**Consultation Response from KC,
Highways Development Management**

2024/91591 Land off, Bankwood Way, Birstall Retail Park, Birstall, Batley, WF17 9DT

Variation conditions 2-6, 15, 29 on previous permission 2021/92528 for erection of retail development, associated parking, servicing areas and landscaping

Date Responded:23-10-2024.

PROPOSED SITE/SURFACING PLAN - PLANNING

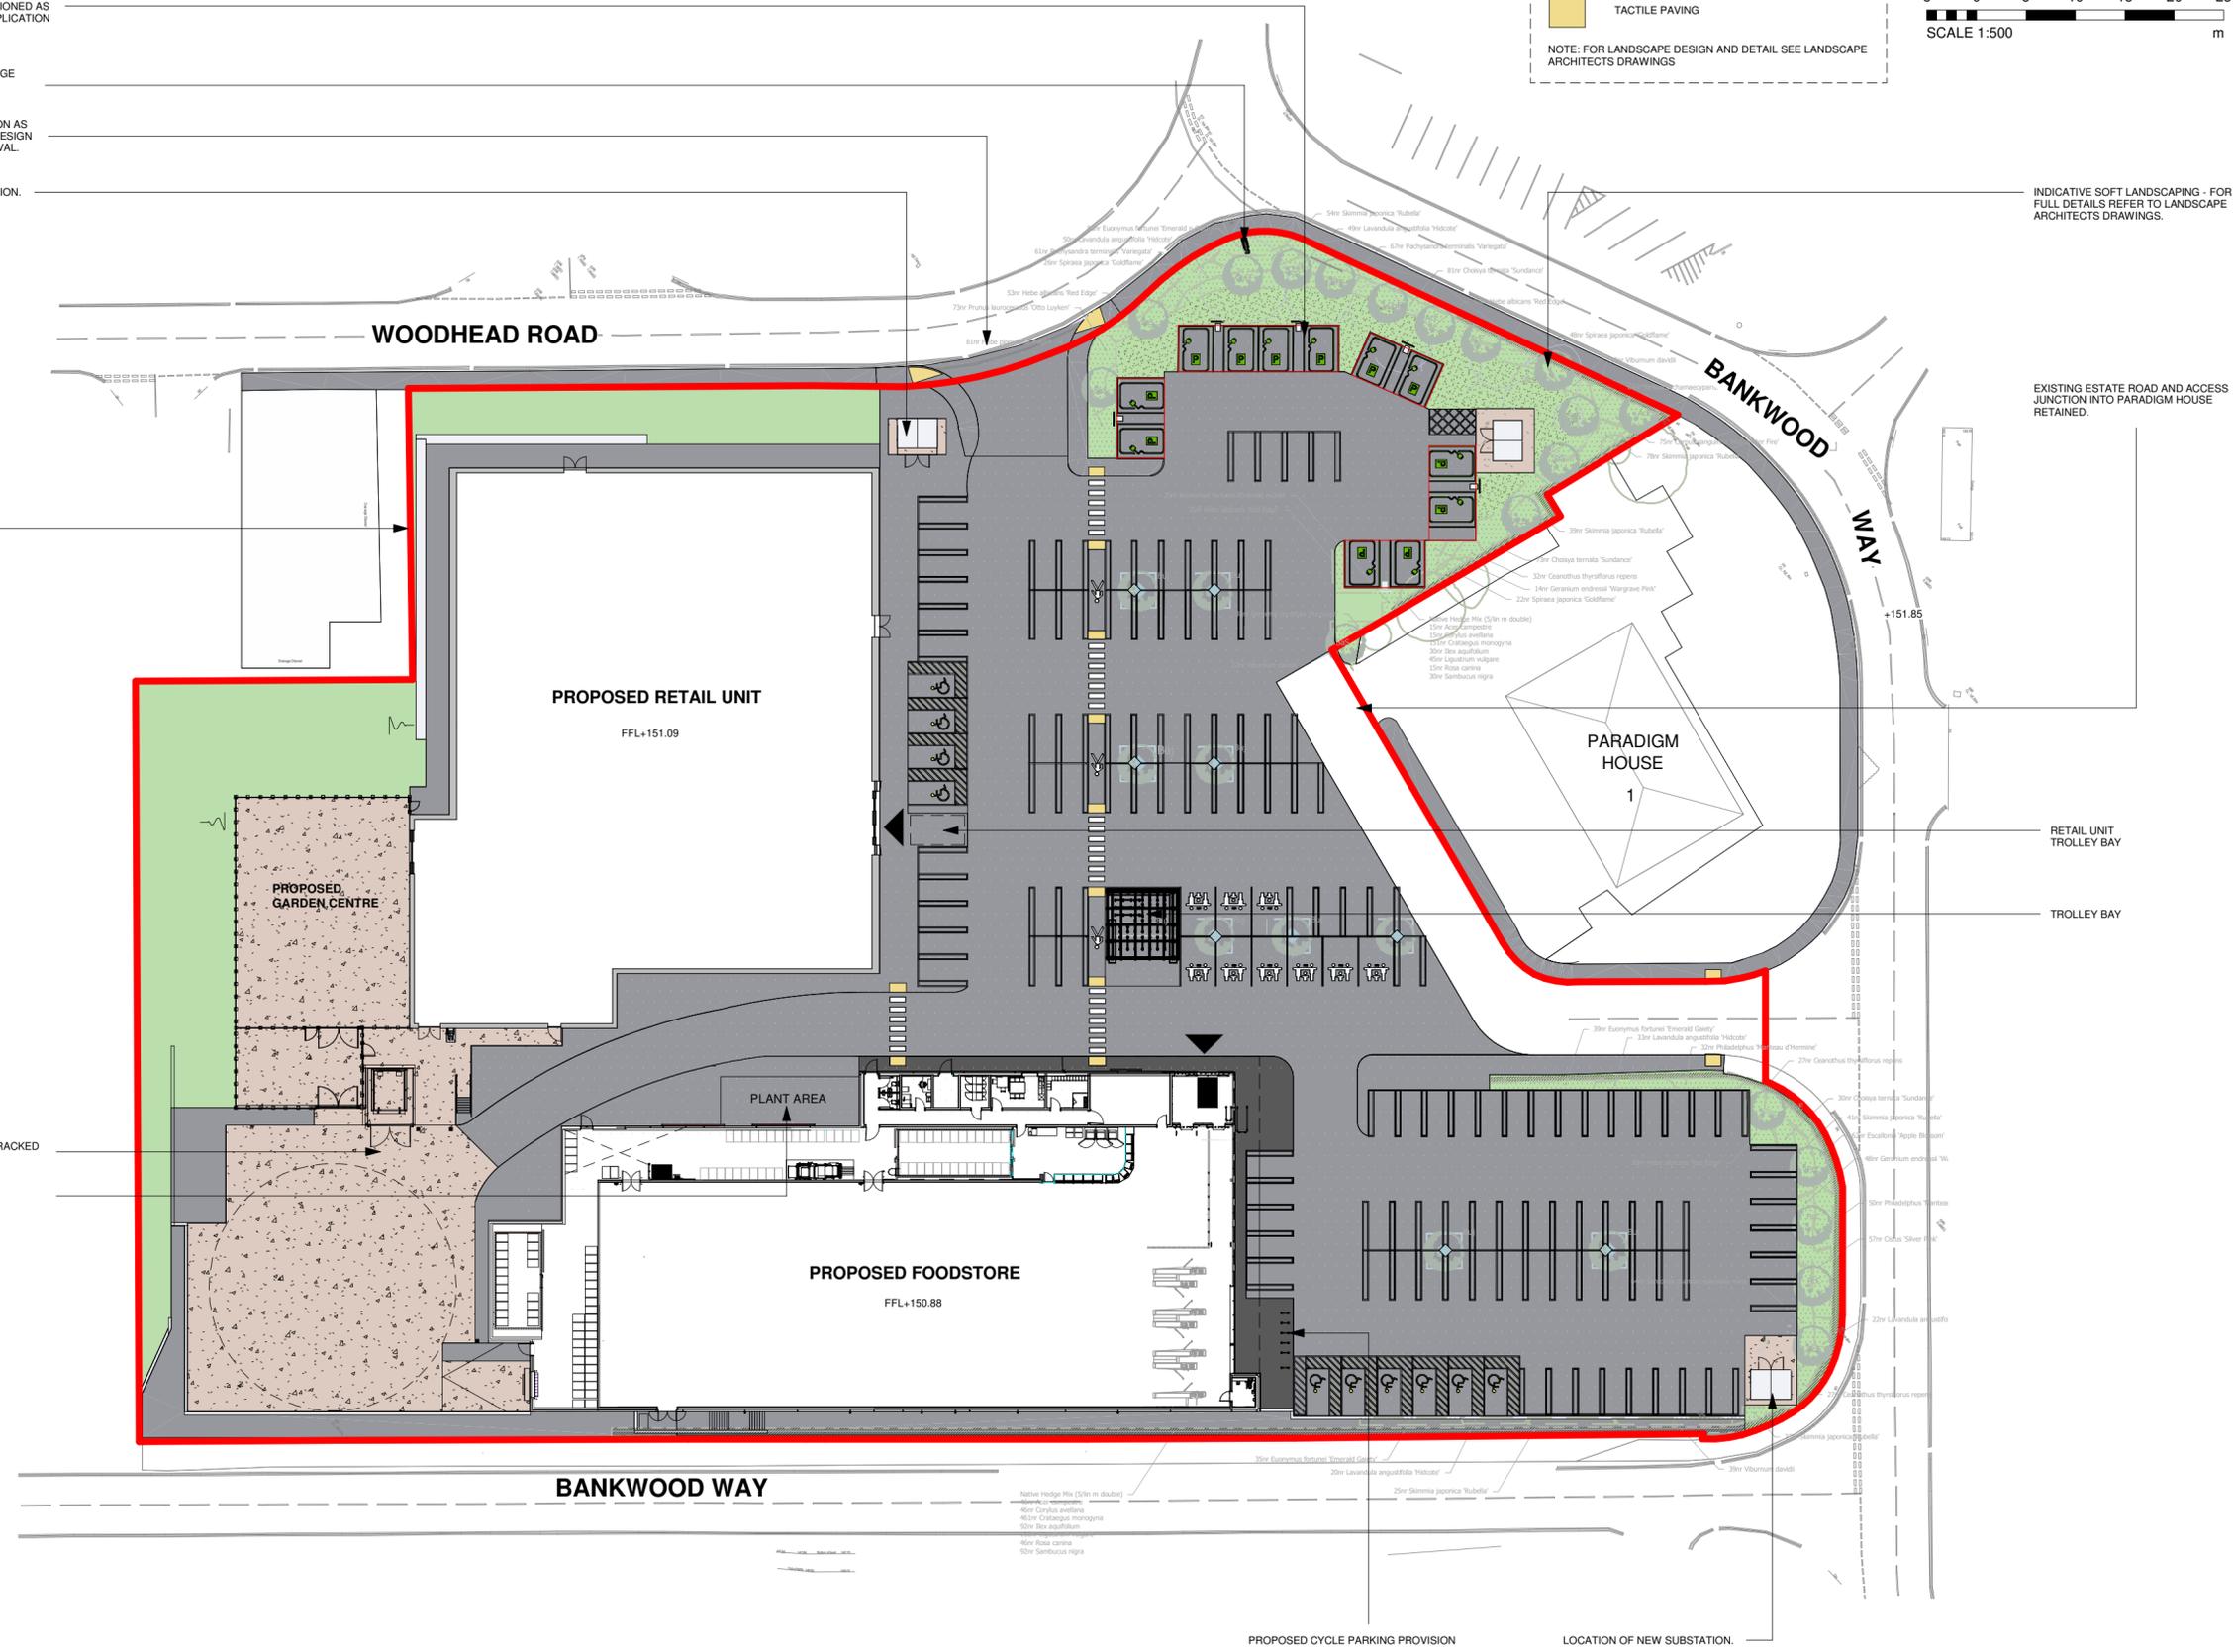
The revised layout will result in a slight reduction in spaces overall, however there will be an increase of 10 EV spaces, and there will be no change to the number of accessible spaces and parent and child spaces.

Given that the proposals are minor with just a slight reduction in parking provisions and that access arrangements are unchanged Highways Development Management have no objection to the proposals.
